**KIRKLEES METROPOLITAN COUNCIL
INVESTMENT & REGENERATION SERVICE**

| Reference No: | 2025/62/90146/E |
| Site Address: | Textile Chambers, Hick Lane, Batley, WF17 5HW |
| Description: | Change of use of vacant textile chamber former office (Egi use) to form cafe and restaurant on ground floor, one residential apartment (C3 use) on first floor, erection of single storey side extension, installation of raised outdoor seating area and internal alterations (within a Conservation Area) |

PROPOSED FRONT ELEV A
SCALE 1:200

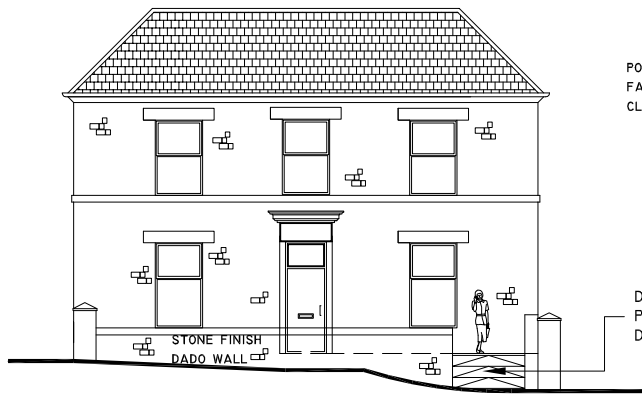
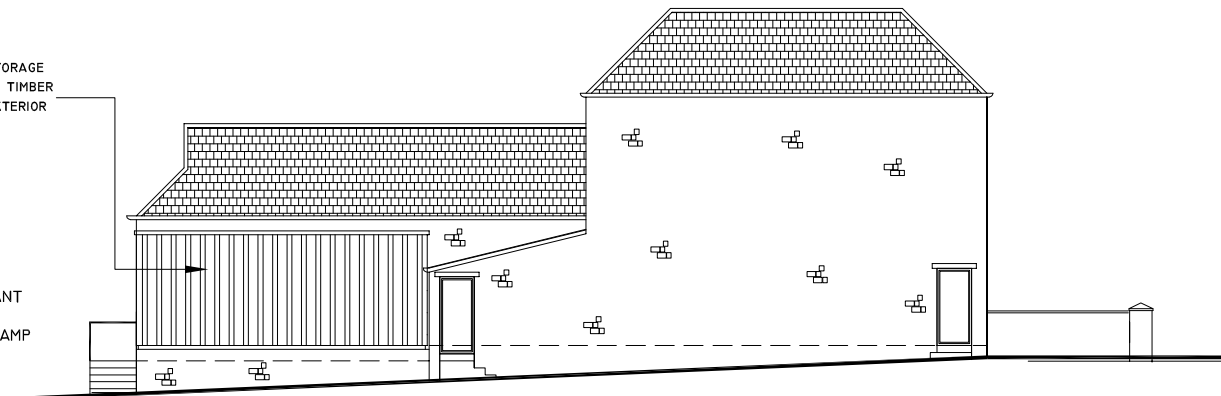
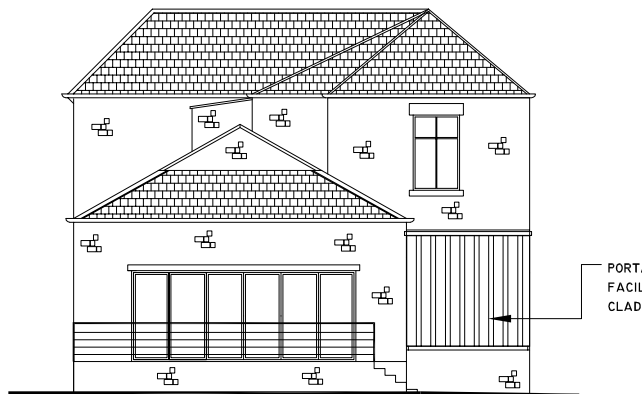
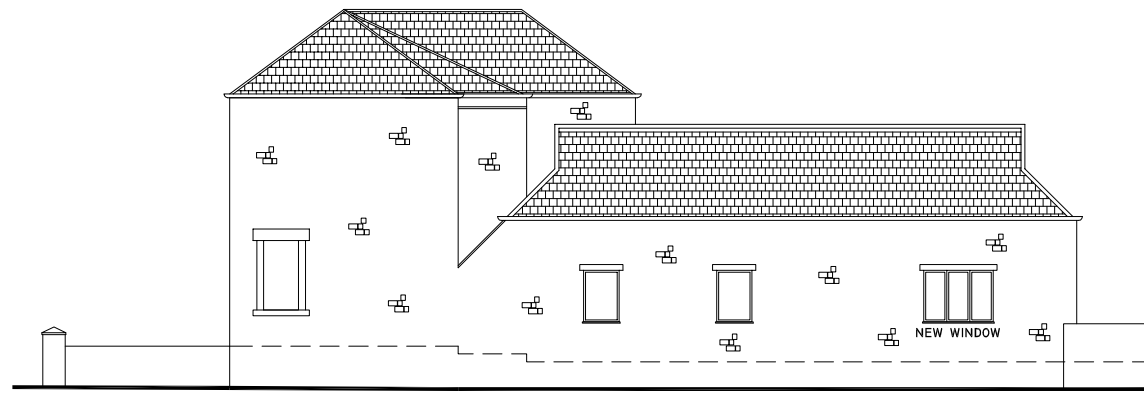
Officers raised concerns regarding the loss of the door frame and architectural details as well as the loss of symmetry, which is characteristic of the age of the property. Similarly, the proposed veranda was considered to cause harm to the visual appearance of the principal elevation of the property. 2 sets of revised plans were received by the agent. The final revision revised the front elevation back to as existing with the inclusion of a raised seating area.

The redevelopment of the building would include a raised seating area to the front of building, a porta cabin style extension to the rear, and a raised area with a large, glazed window to the rear. It is noted that the scheme initially proposed significant alterations to the front of the building, however officers had significant concerns regarding the impact of this on visual amenity and the historic character and therefore amended plans have been received which mainly retain the front elevation as existing other than the proposed seating area.

The proposed raised seating area would be located to the front of the building and would be approximately 1m in height with a stone dado wall which would have a maximum height of 1.6m with stone piers at either end. It is noted that there is an existing raised section with a curved dado wall which was historically mirrored by another raised section. The proposed would be in a similar location to the historic raised area however it would extend across the full width of the property. It is therefore considered that this would not cause significant harm to visual amenity or the historic character of the area.

PROPOSED GROUND FLOOR PLAN

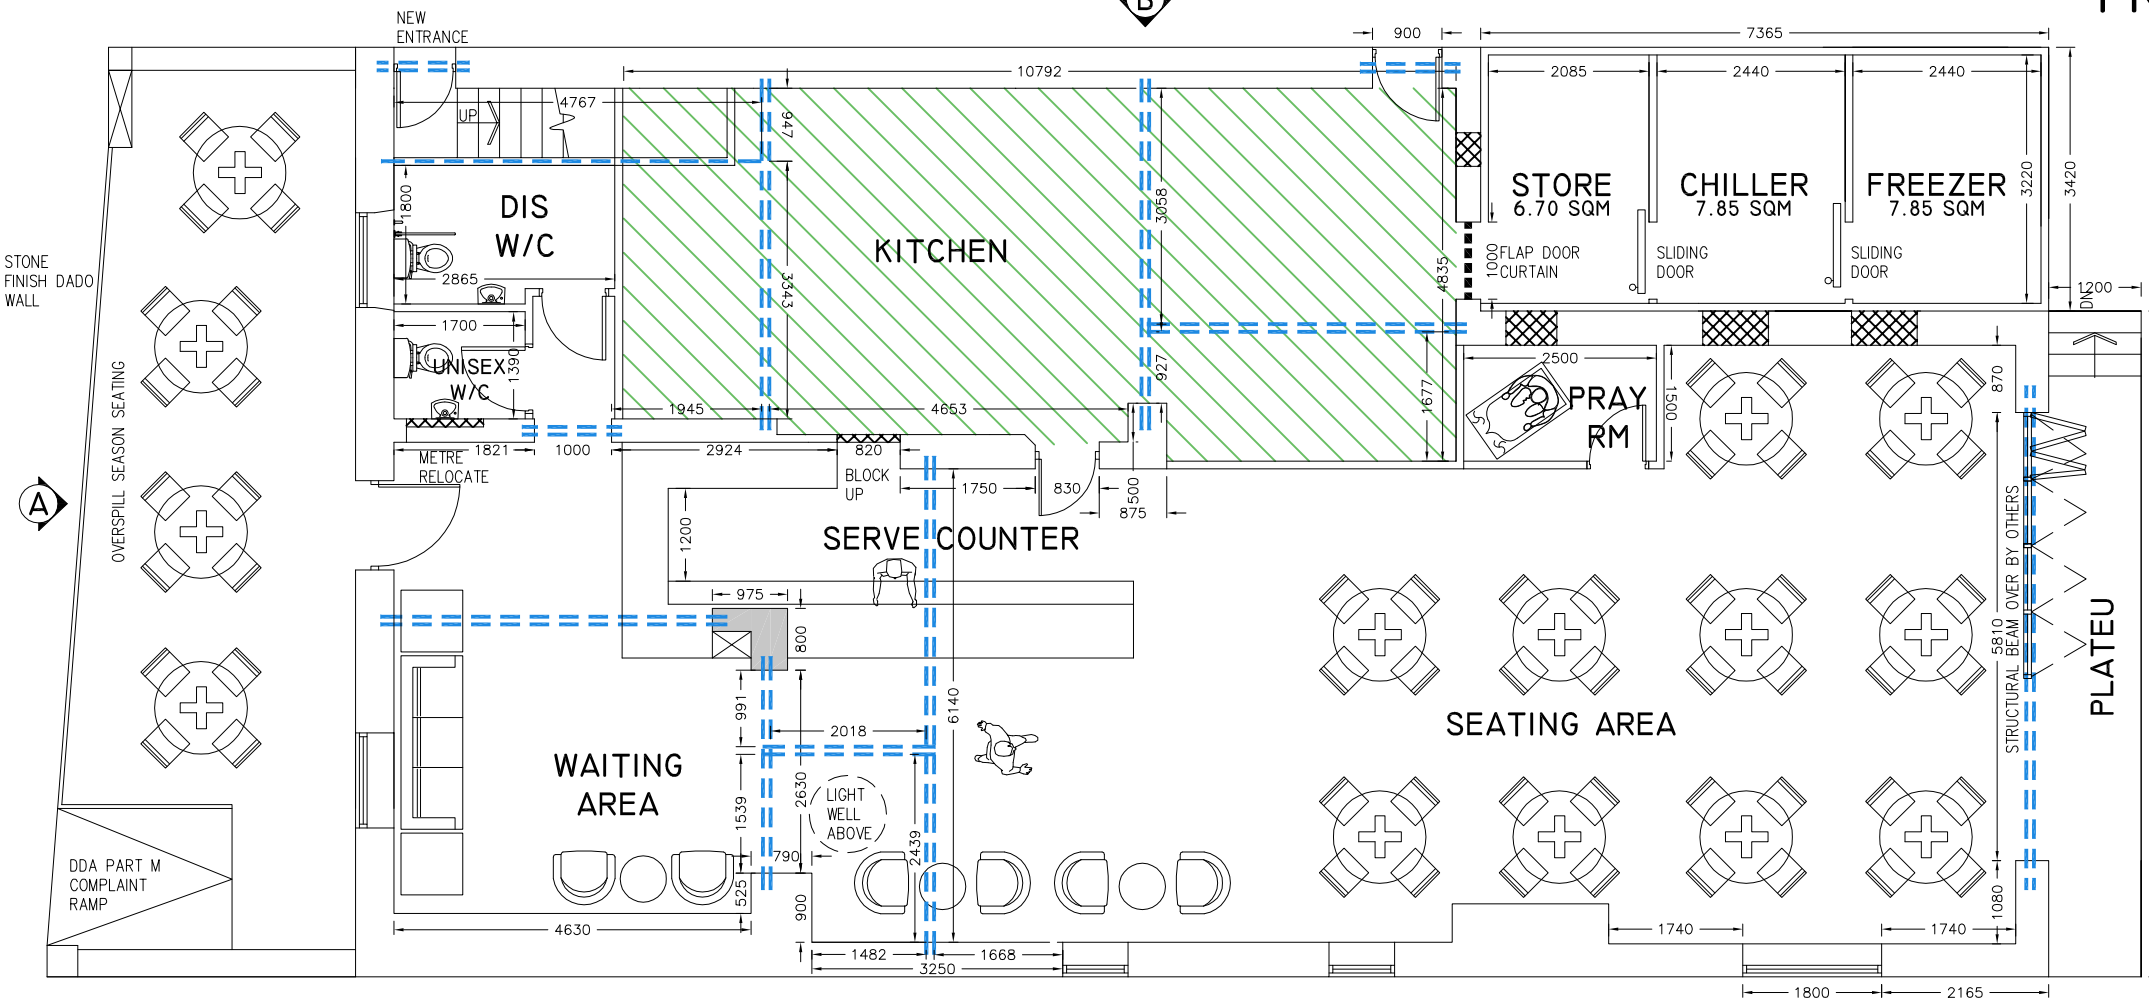
The proposed 'porta cabin storage facility' would infill the section to the northern corner of the property. Whilst a porta cabin is not an ideal addition from a visual amenity perspective, this is located to the rear of the property and would not be visible from the front of the building or Hick Lane/Wellington Street/Commercial Street and therefore would not be prominent within the conservation area. This would be finished in timber cladding which would somewhat shield the porta cabin design, thus mitigating the harm.

The location of the proposed bin store is greater than the recommended minimum distance of 8m from the bin store to the adopted highway. A bin collection/presentation point should be located adjacent to the public highway and must not obstruct the adopted highway or the car park access road. This would be secured by condition should approval be recommended.
